Preliminary Acceptance Punchlist
El Paso County – Department of Public Works - Stormwater Section

Project Name:	Bent Grass Residential F2
EDARP Filing Number(s):	SF1914, CON2022
ESQCP Number:	ESQ228
Attendees:	DPW SW: Dylan Finley, Ben Jones DPW Development Services: Spencer Pirzadeh, Brad Walters Developer: George Hart, Erin Ganaway
Date of Walk-Thru:	09/13/2023
Walk-Thru Number:	1

WATER QUALITY
DETENTION POND (NORTH)

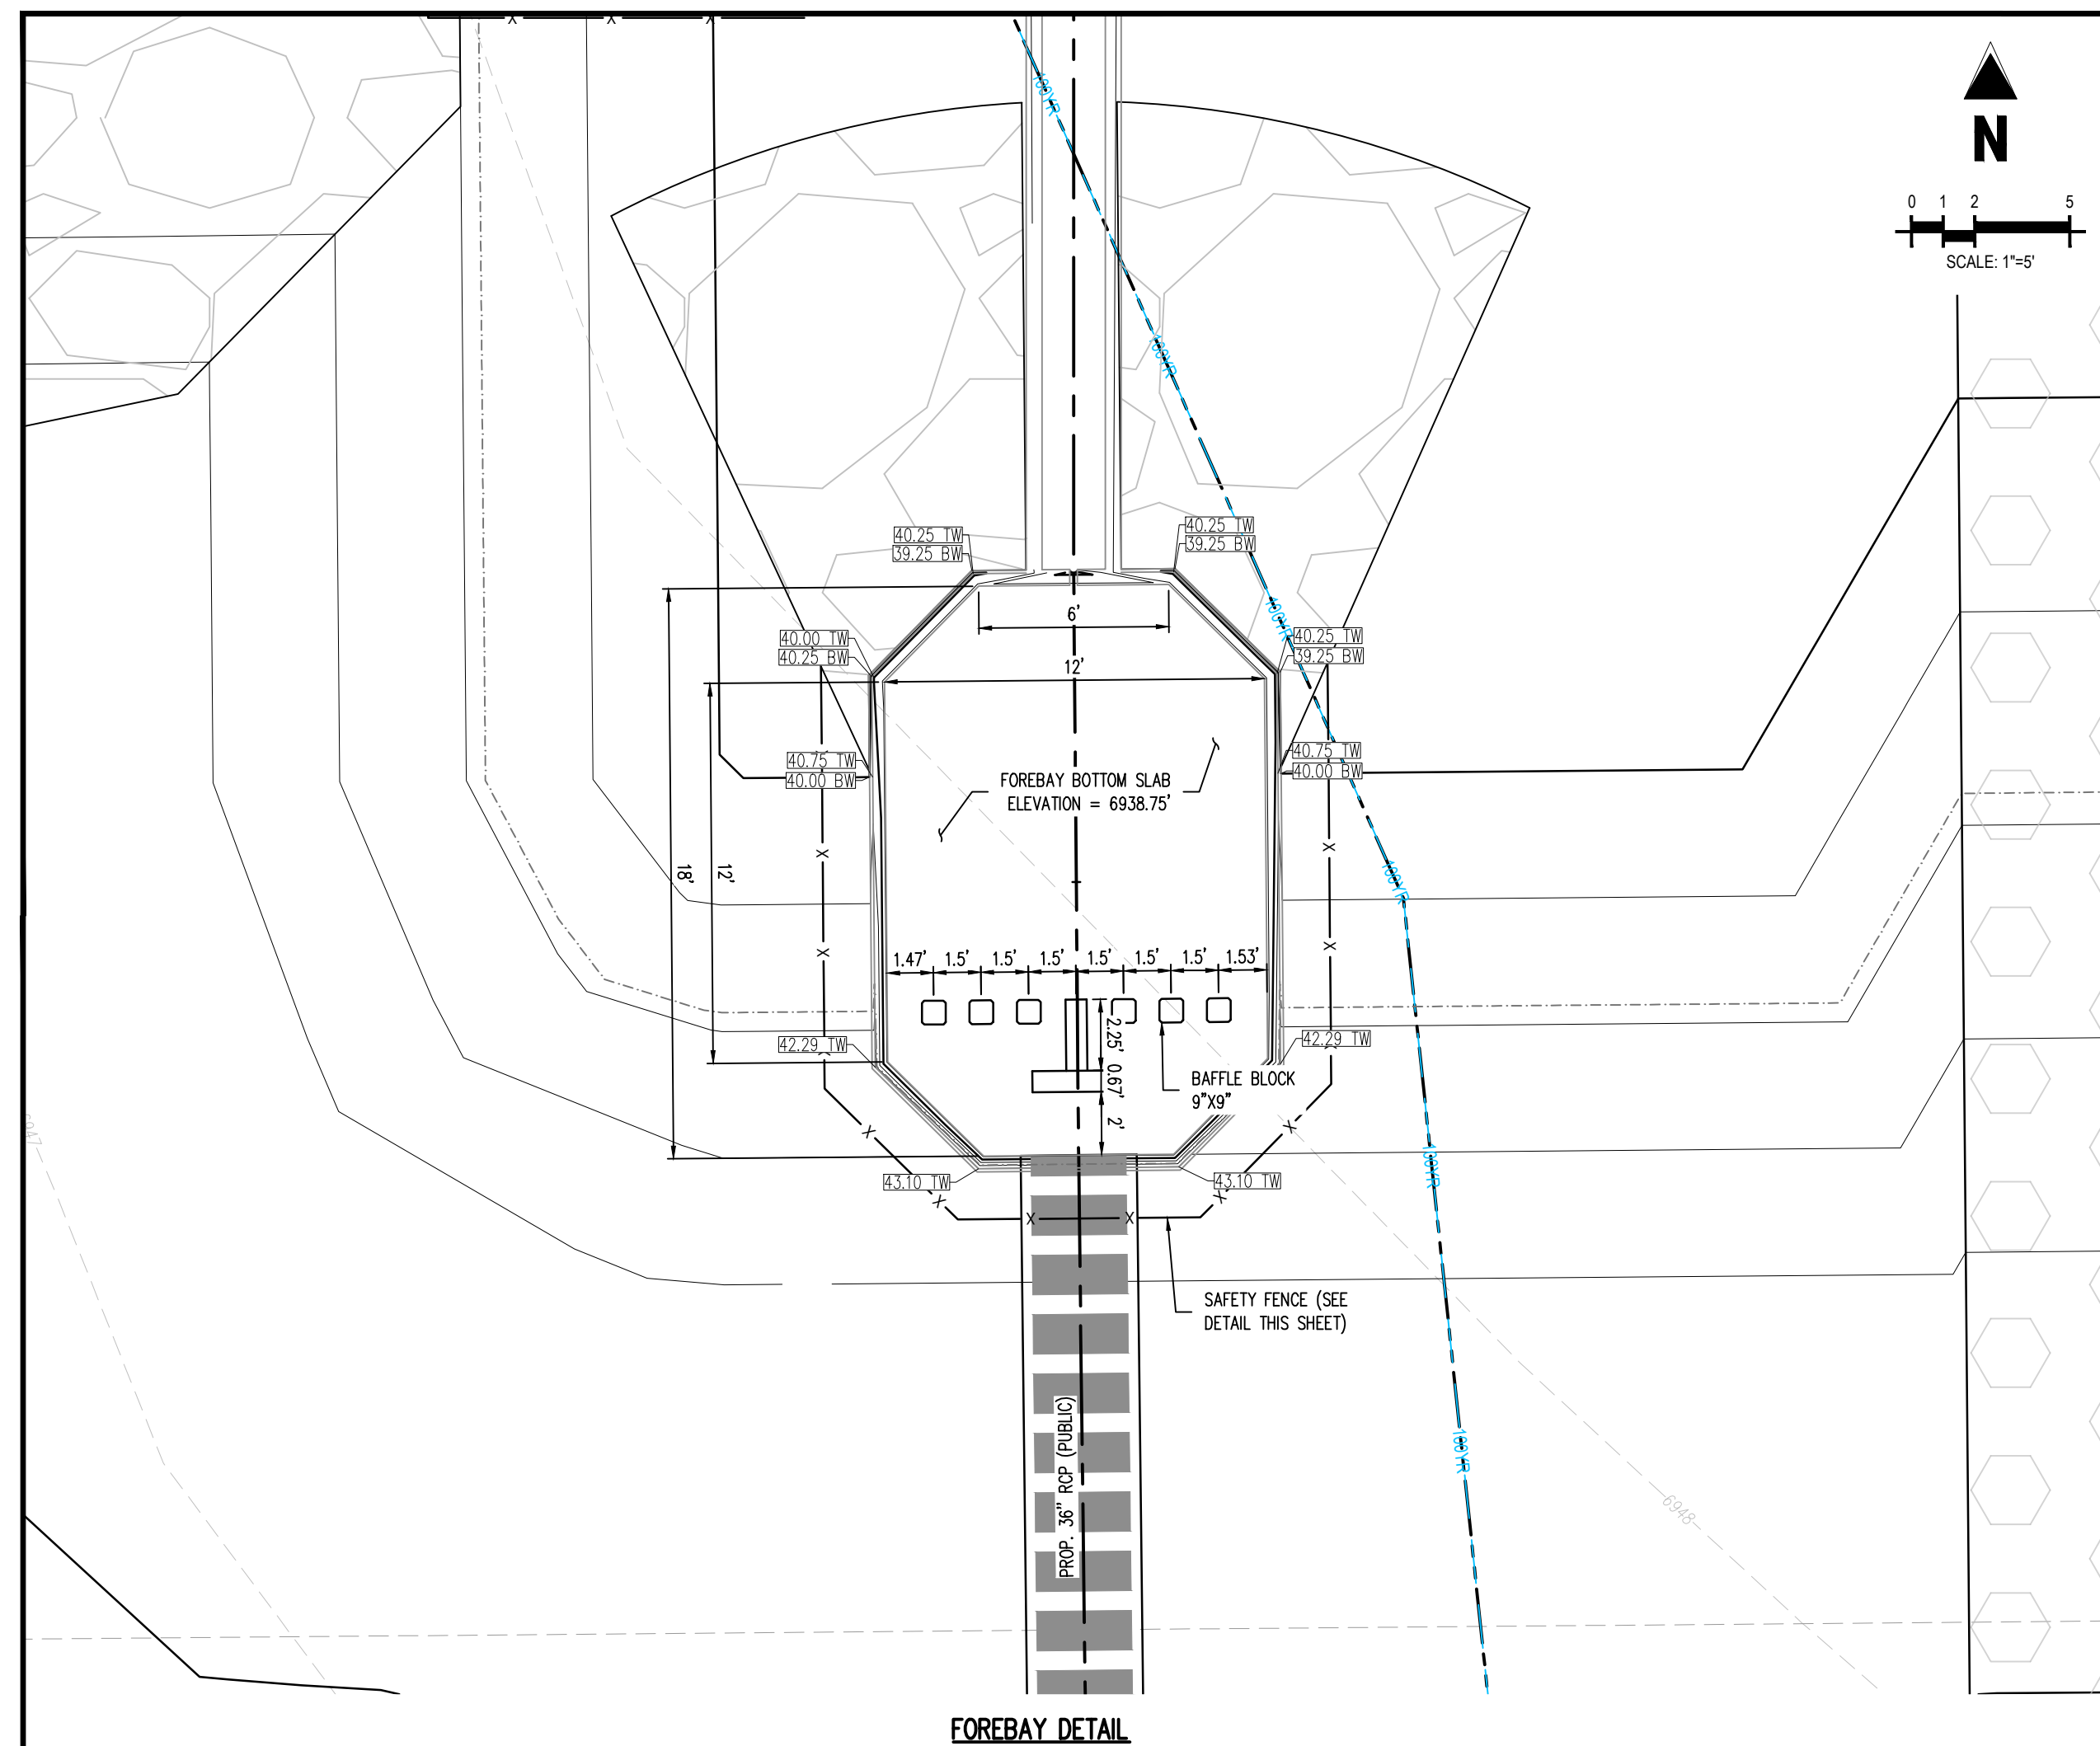
- Missing pond sign (“proposed storm facility”)
 - Well screen type not acceptable: diamond plate not allowed. Drawing calls for Johnson vee wire. See sheet G6.01. See email from Glenn Reese from 11/2/2022 titled “Screen information – SF1914 – Bent Grass F2.”

**WATER QUALITY
DETENTION POND (SOUTH)**
SF1914
5/13/2020

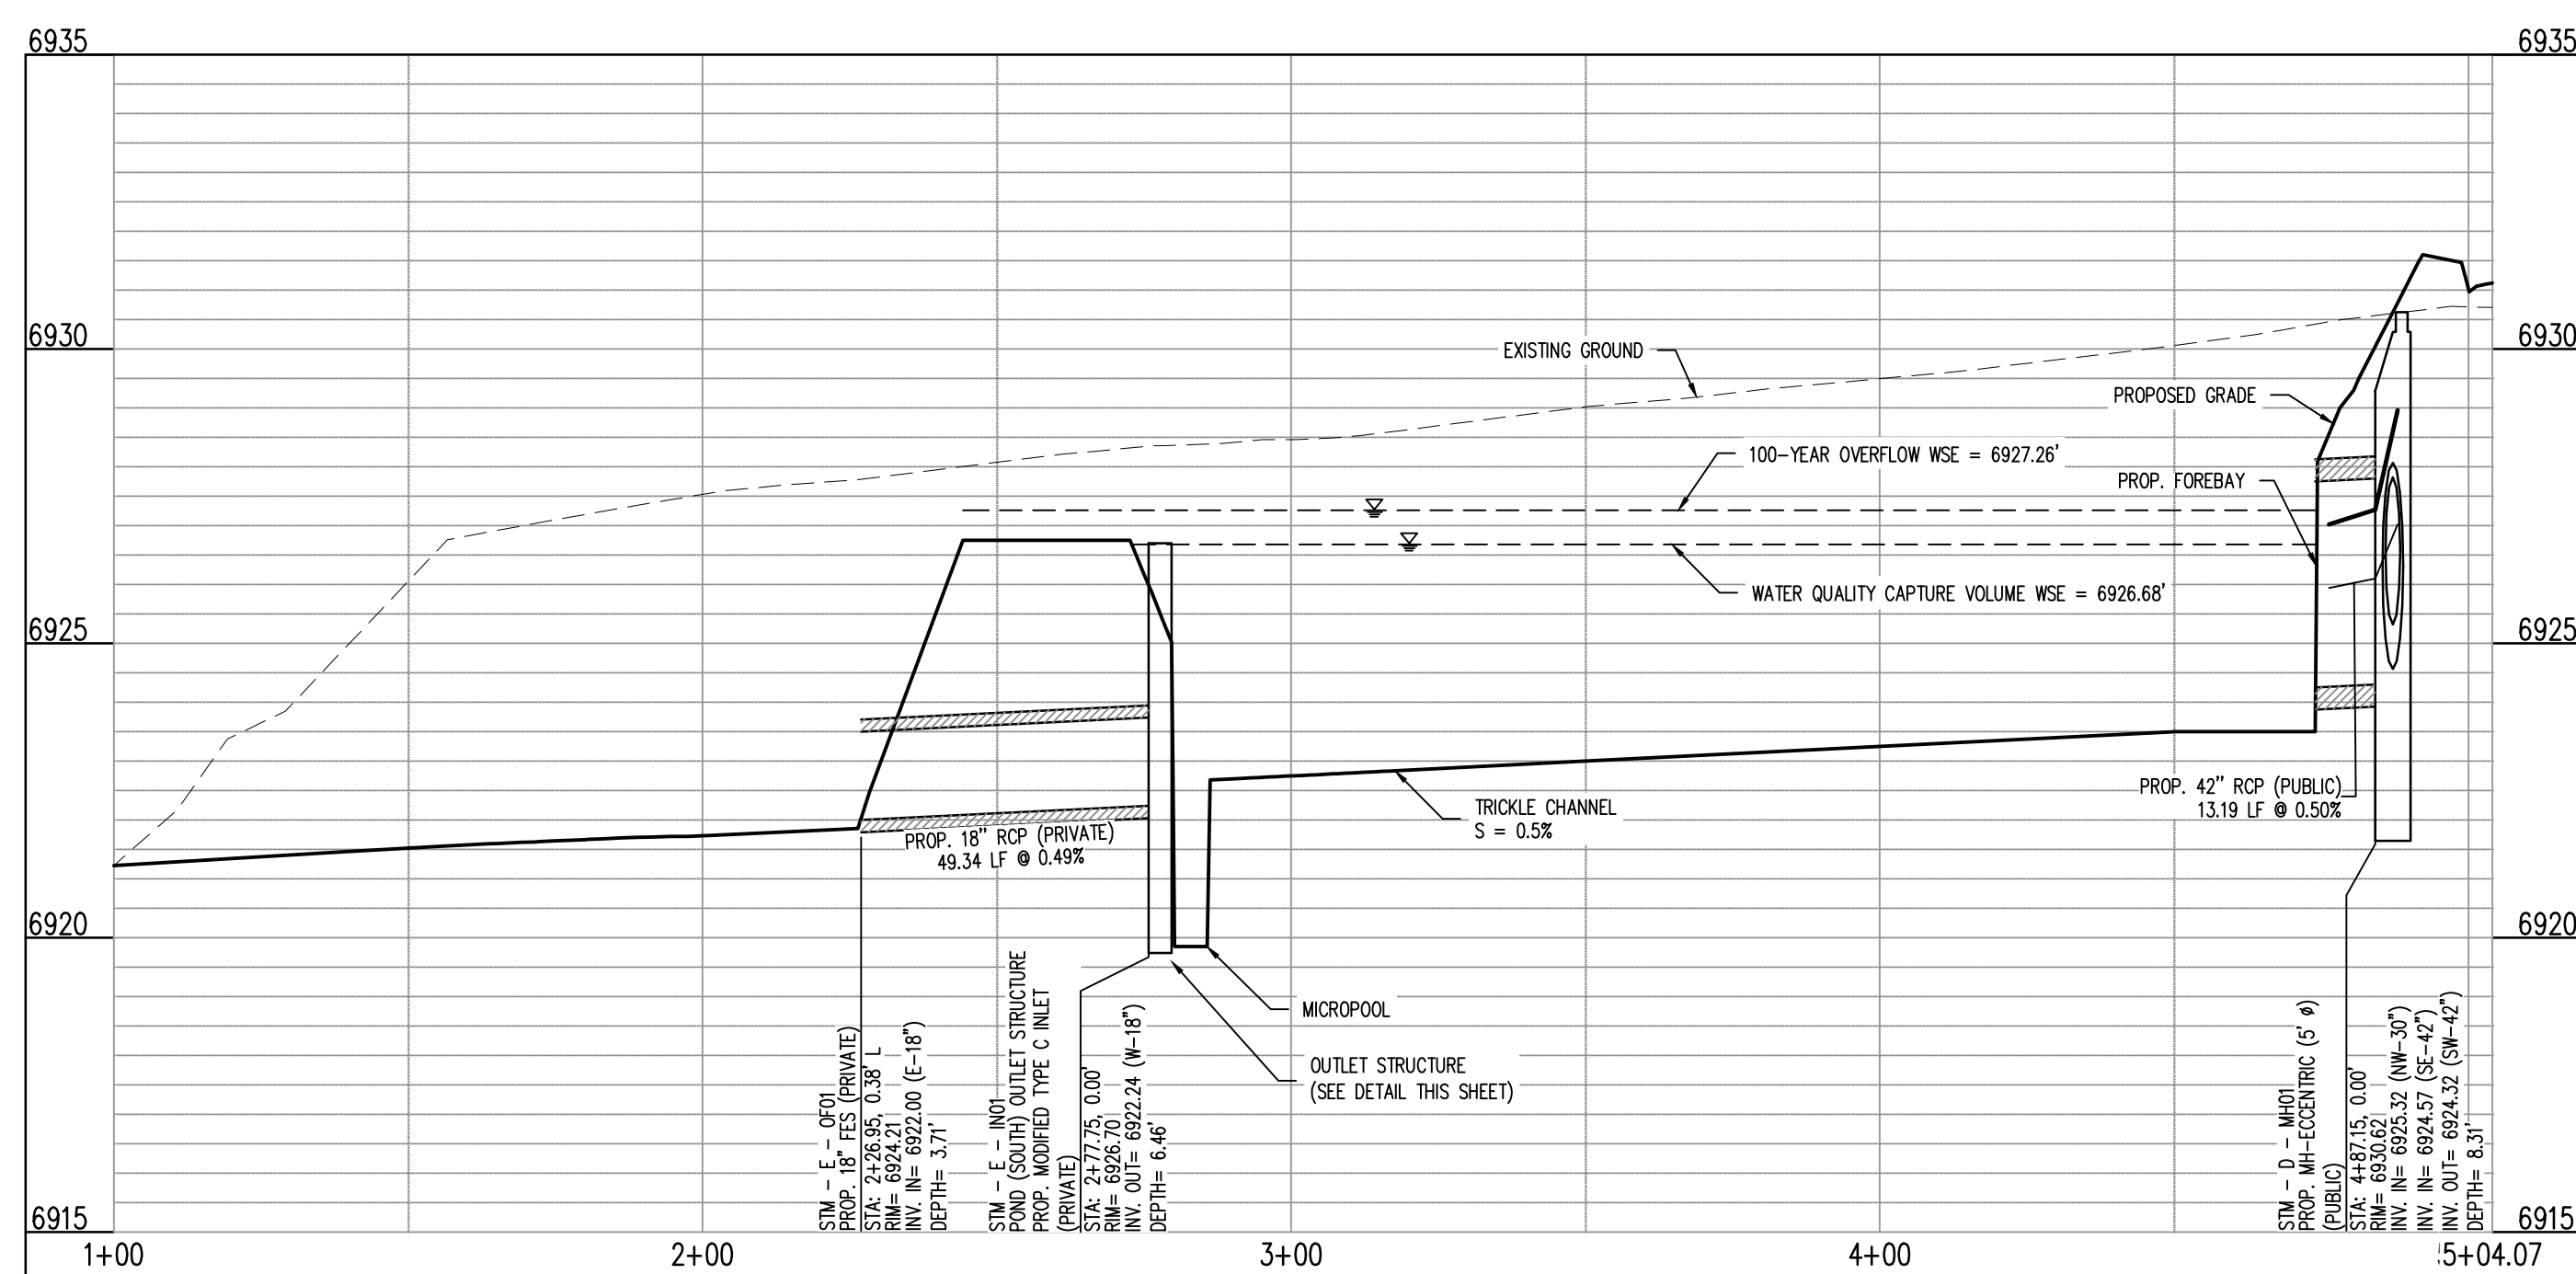
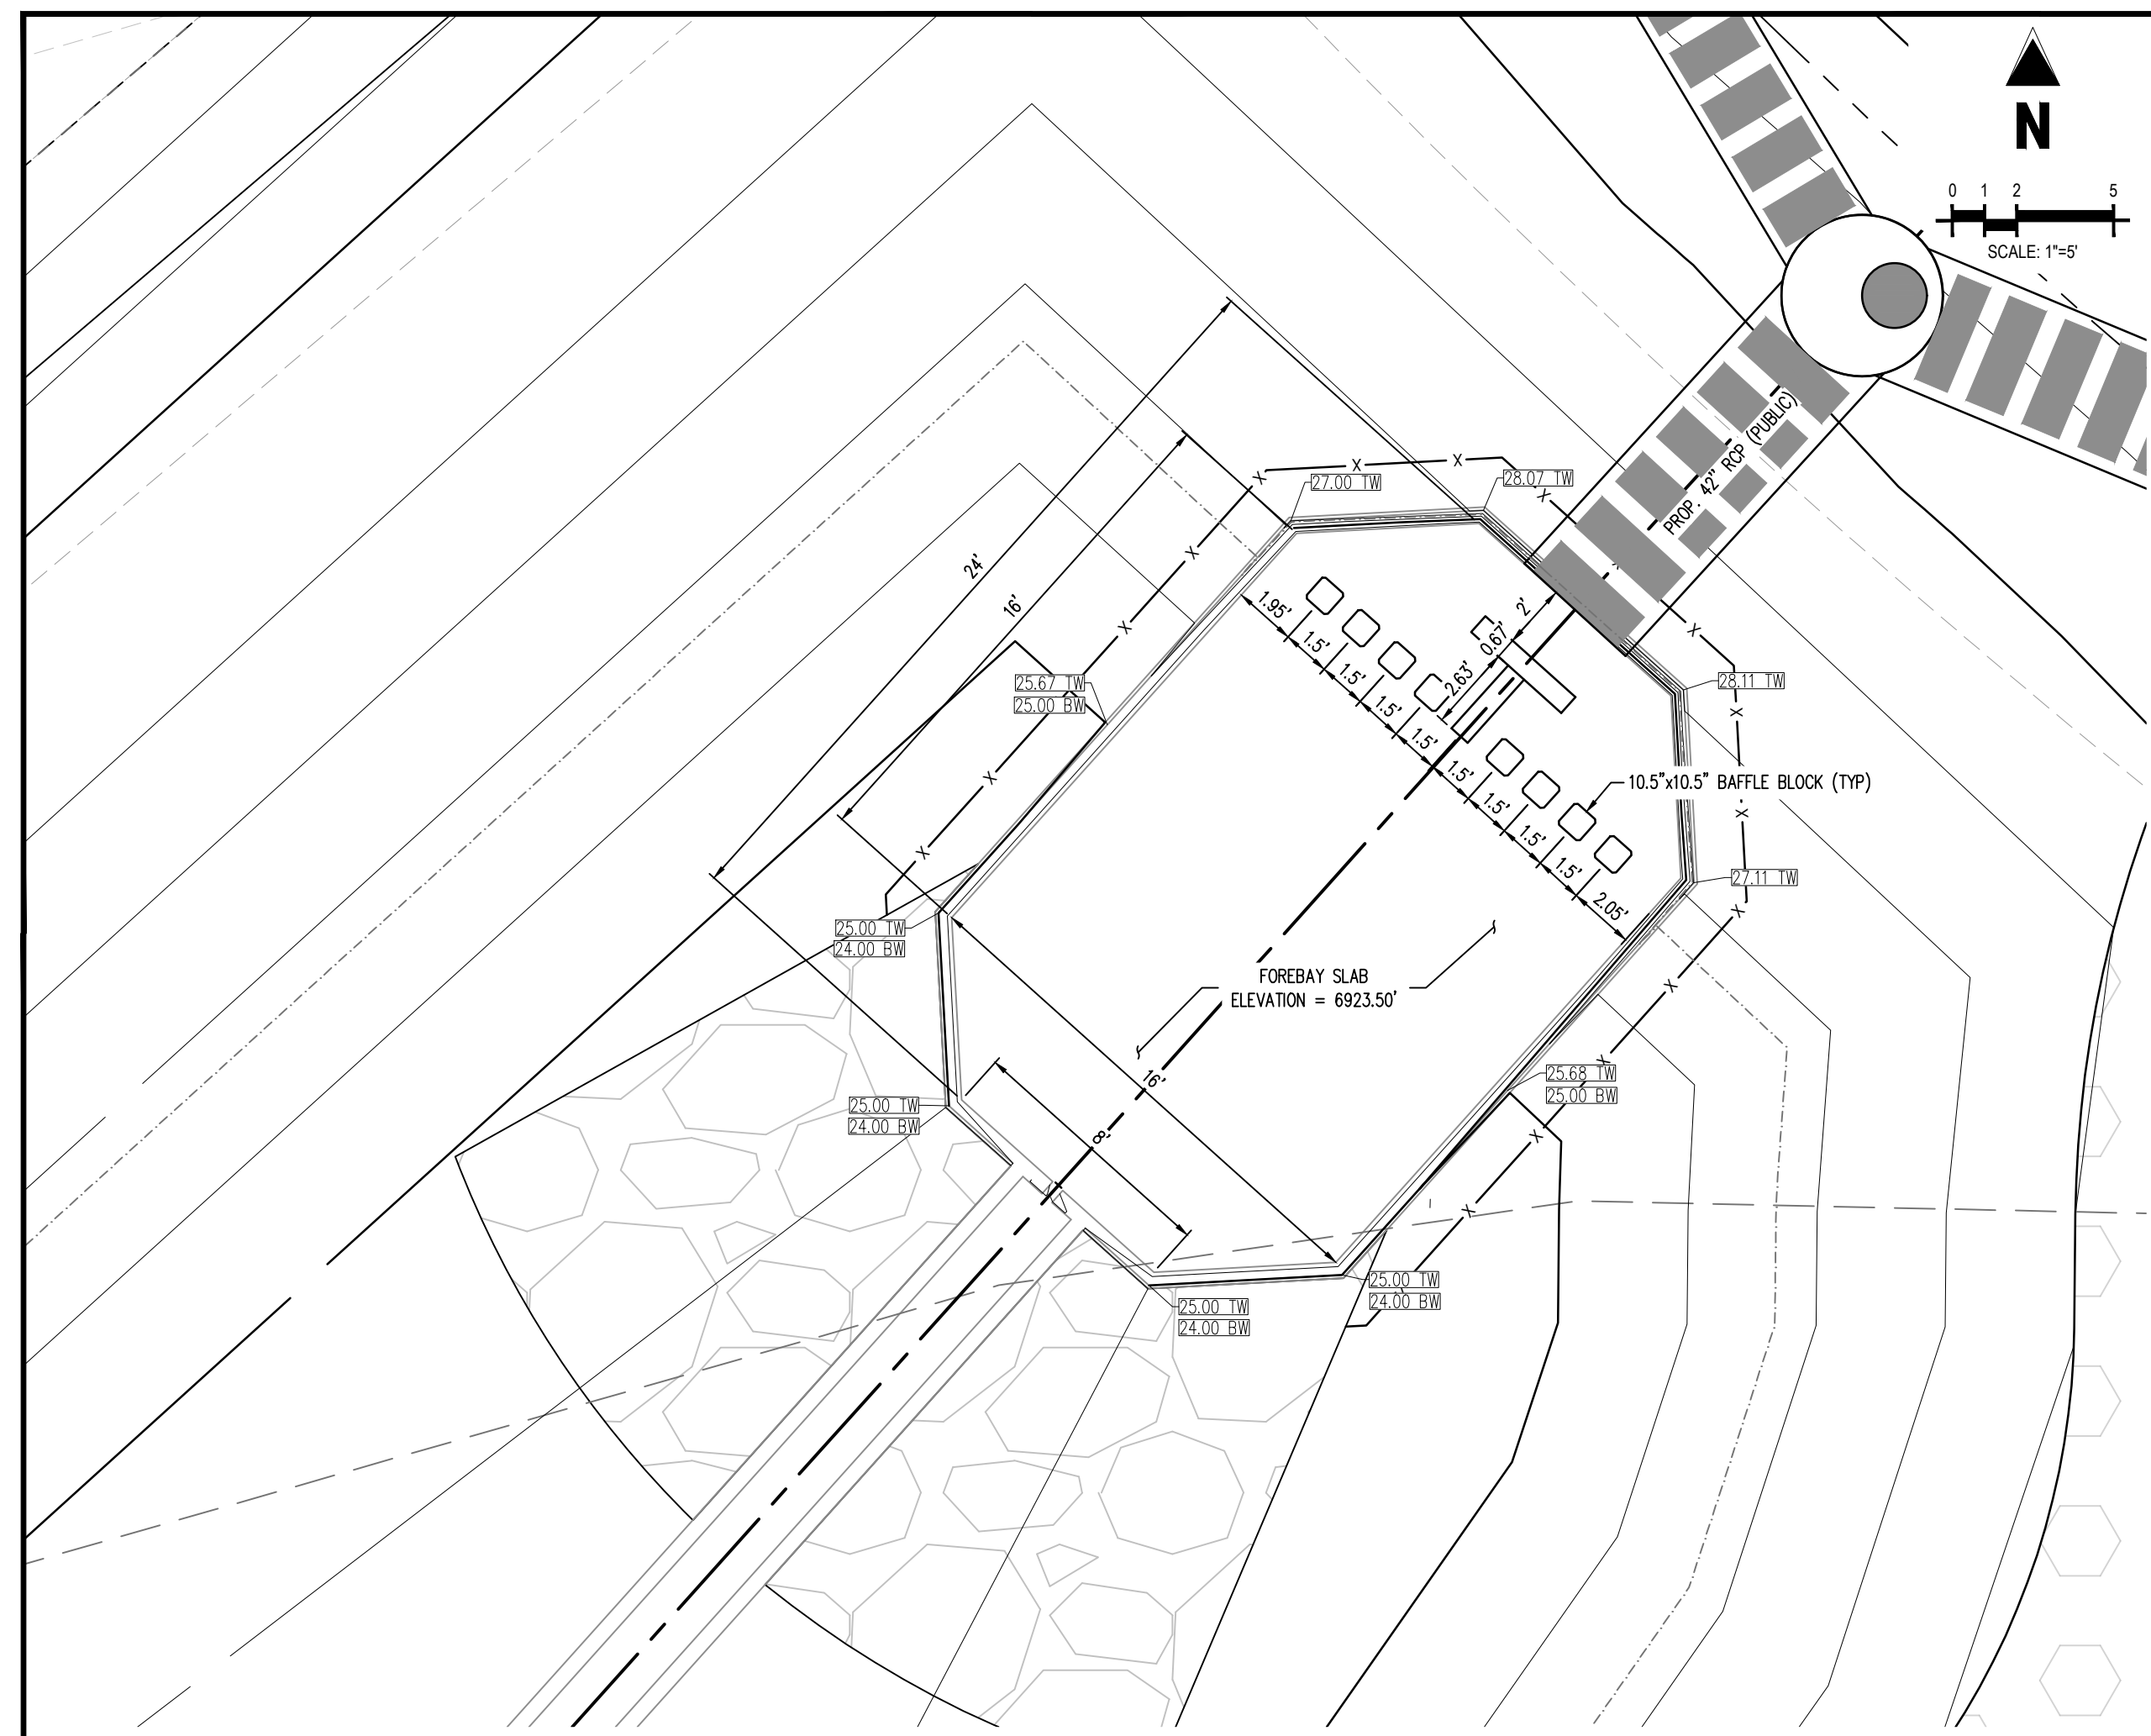
- Findings listed on 6/23/22 punchlist and still not completed:
 - Grade pond bottom to min 3% slope towards trickle channel. Cat tails present in low points where water is not draining.
 - Well screen type not acceptable. See explanation in North Pond above.
 - Missing pond sign (“proposed storm facility”).
 - Install restrictor plate on outlet pipe per plan and UD-Detention spreadsheet.
 - Confirm gasket at orifice plate.
- Remove debris from outlet structure.
 - Outlet structure inspection could not be completed because of amount of debris covering it. The PA inspection will be completed once debris is removed.
- Remove sediment from downstream end of pond outlet pipe in Swale C.
- Flared End Section missing from downstream end of pond outlet pipe.
